CITY OF ALBUQUERQUE

March 12, 2018

**Re: 9000 Alameda Blvd. Grading & Drainage Plan
Engineer's Stamp Dated Missing
(C20D073)**

ARROYO  
STA: 10+00.00 TO 12+23.57  
\*-ALL STATIONING BASED UPON PROPOSED CENTERLINE

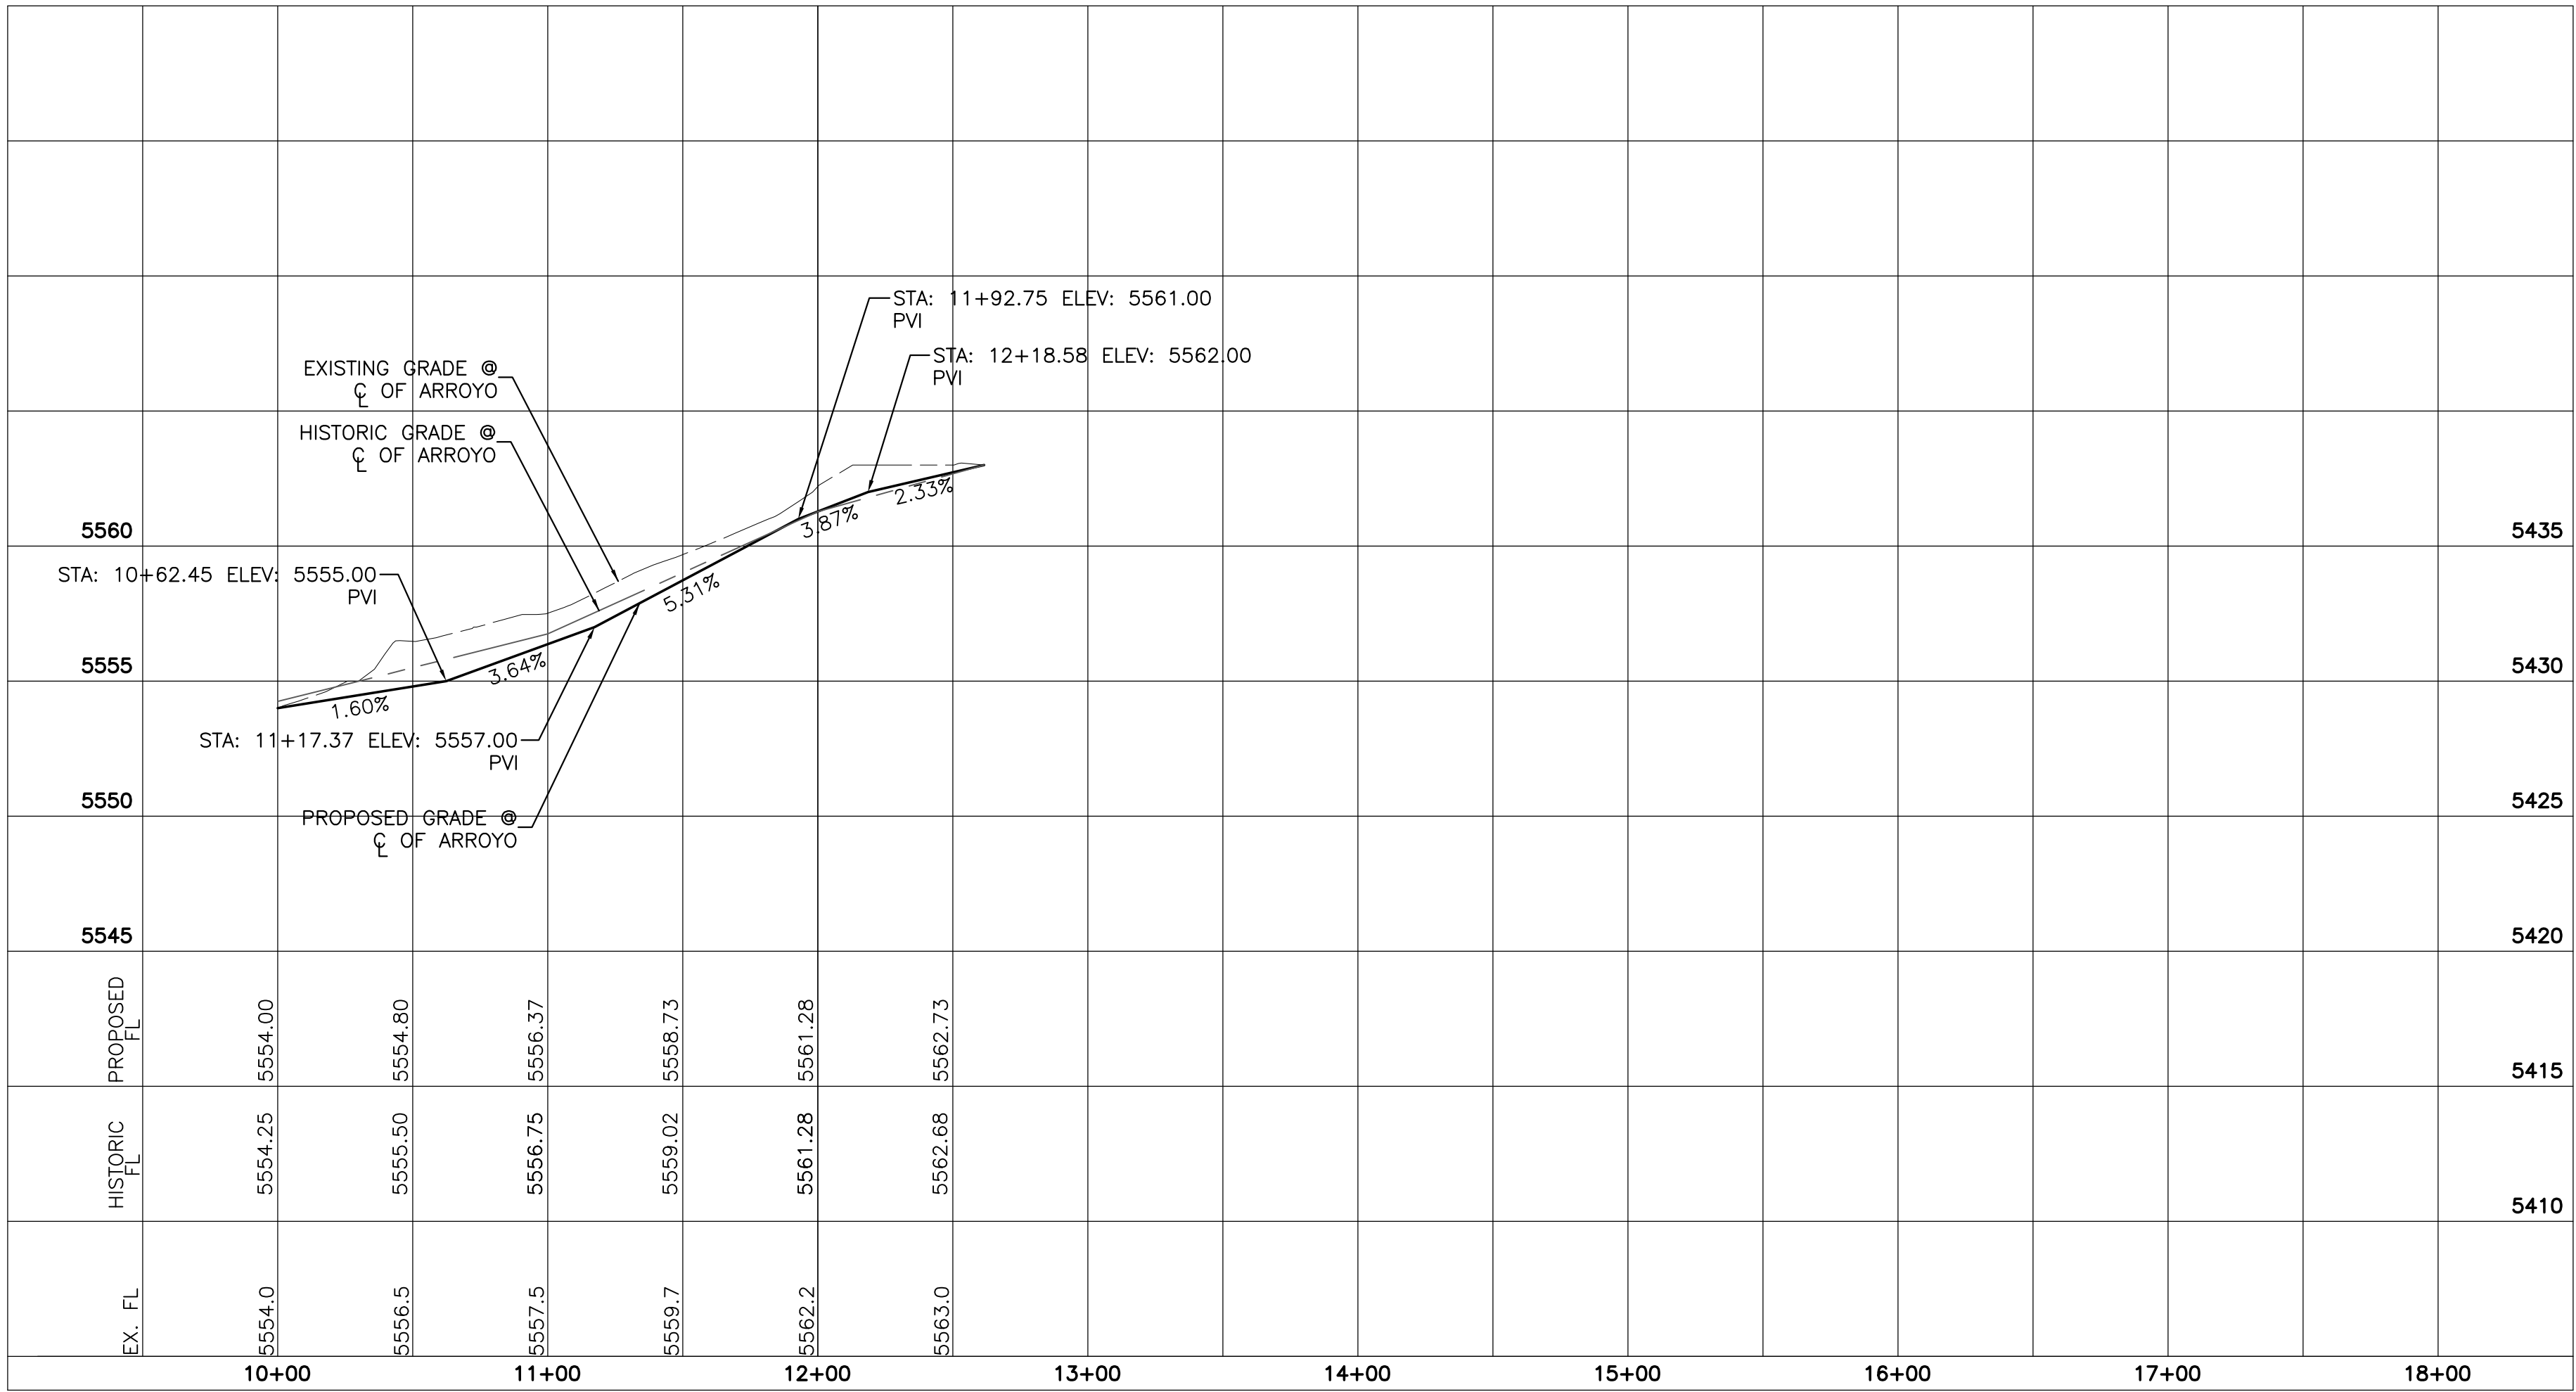
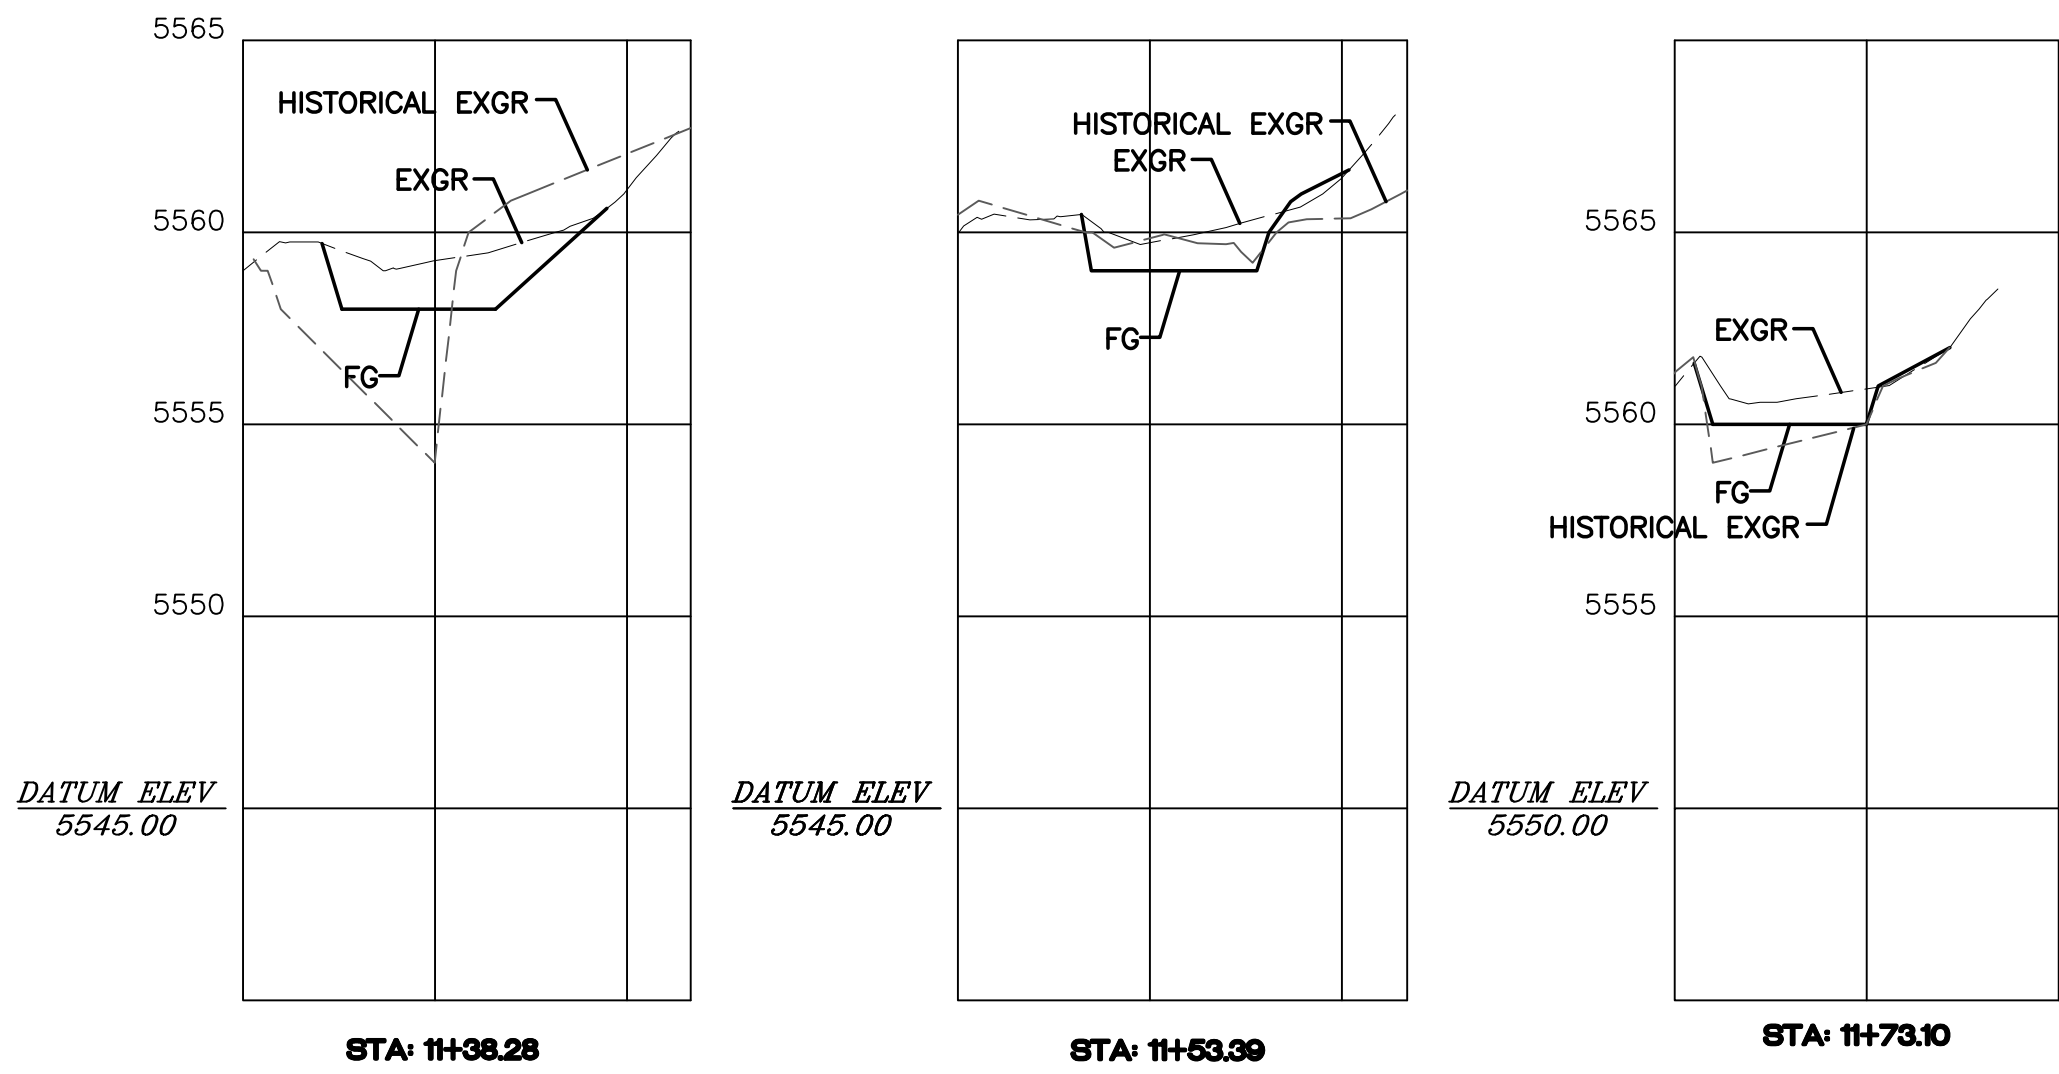
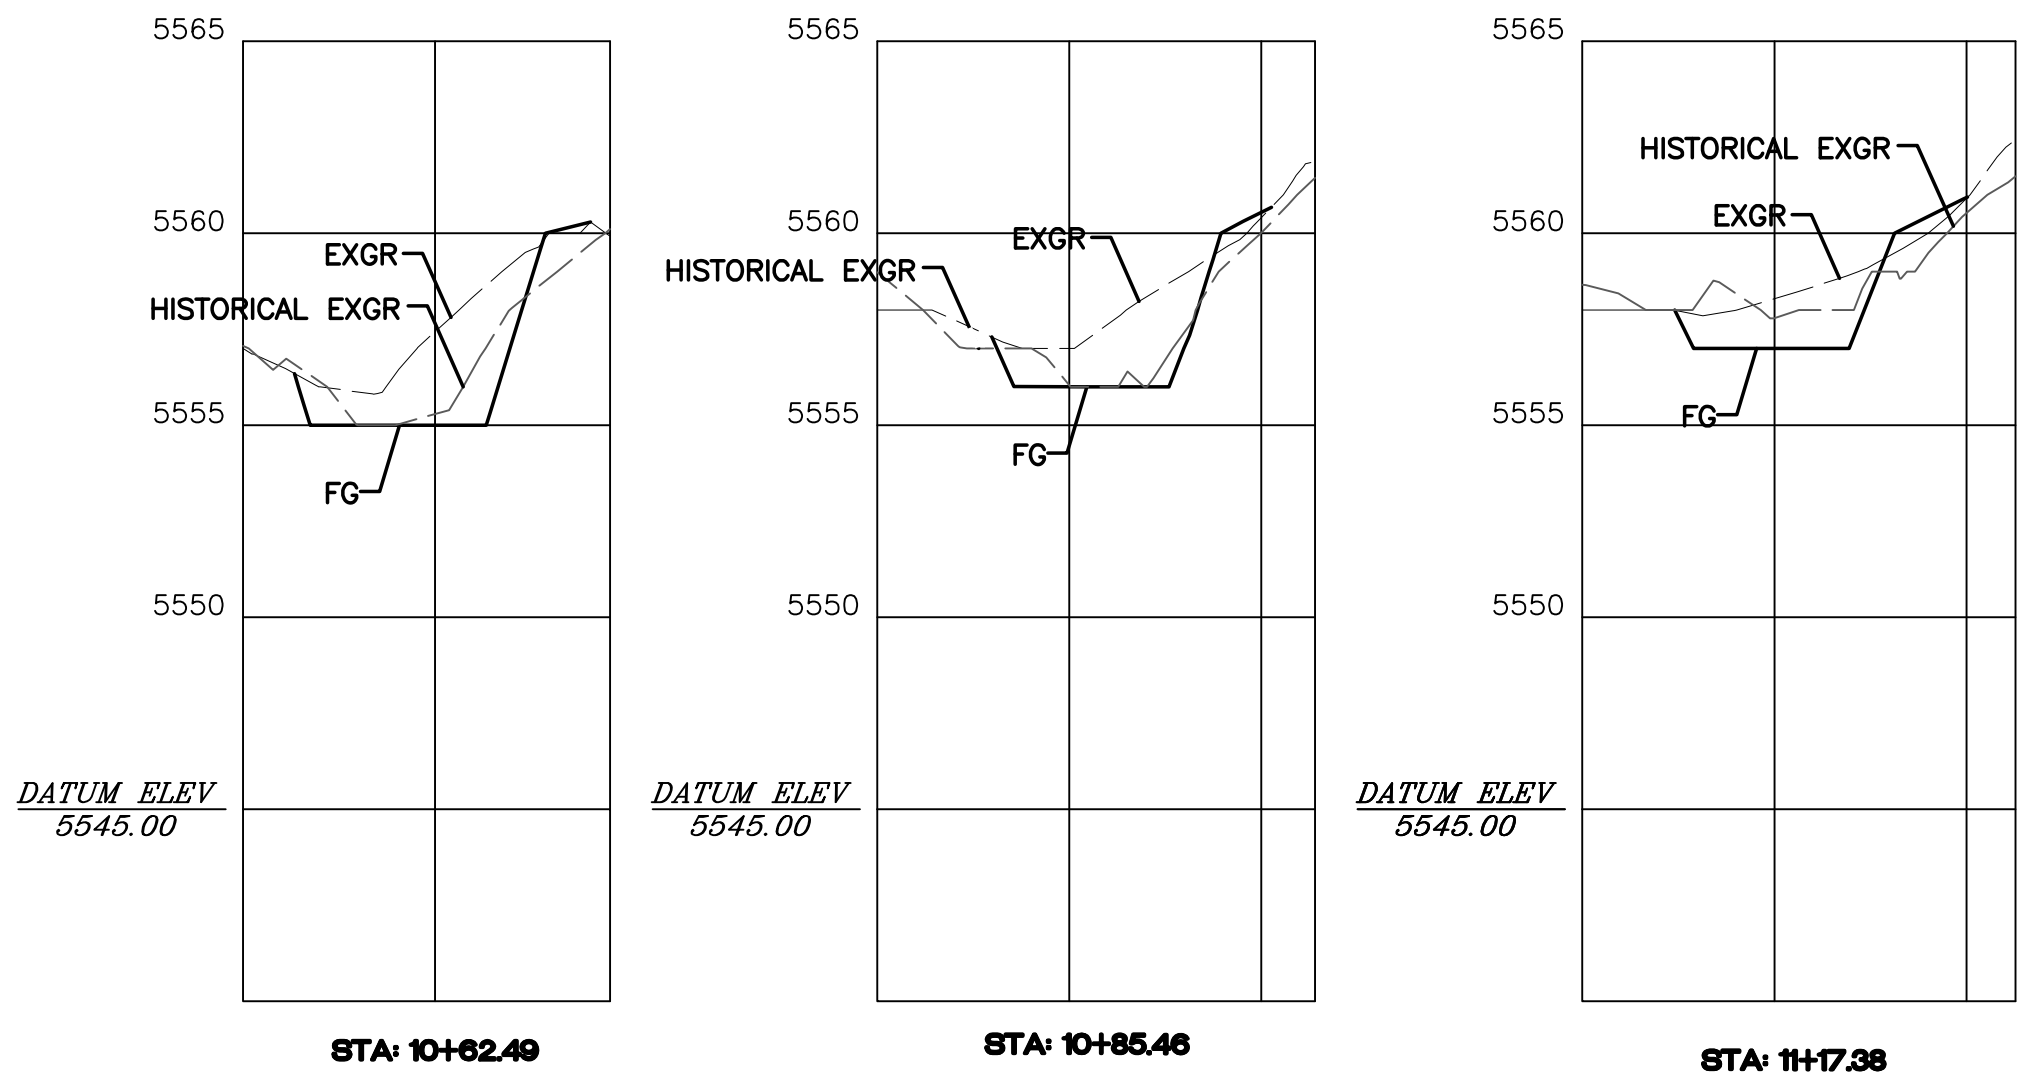
- Add a note prohibiting Construction in the arroyo during the months of July, August, and September.
- Show the proposed grades necessary to restore the floodplain drainage capacity with proposed contours and spot elevations. Verify that the proposed trapezoidal section will restore the original cross sectional area by plotting the finished grade on the sections.

- Include a profile of the arroyo showing existing and proposed grades. Add a typical section, about 30' flat bottom trapezoidal channel.
- Extend the grading upstream of the property about 20' as necessary to restore the original grade there.

- Provide sufficient horizontal and vertical control for construction staking and as-builts.
- Show a Public Drainage Easement 55' wide at the east PL, 105' wide at the west PL, and 70' wide at a point 50 east of the west PL. Provide the signed and notarized original easement to Madeline Caruthers along with a check for 25\$ payable to Bernalillo County.
- Show the relocated fence outside of the Public Drainage Easement, and identify the existing fence to be removed from within the public drainage easement.
- An ESC plan must be submitted to Stormwater Quality Control. After the ESC plan is approved an ESC Permit must be obtained prior to beginning construction.
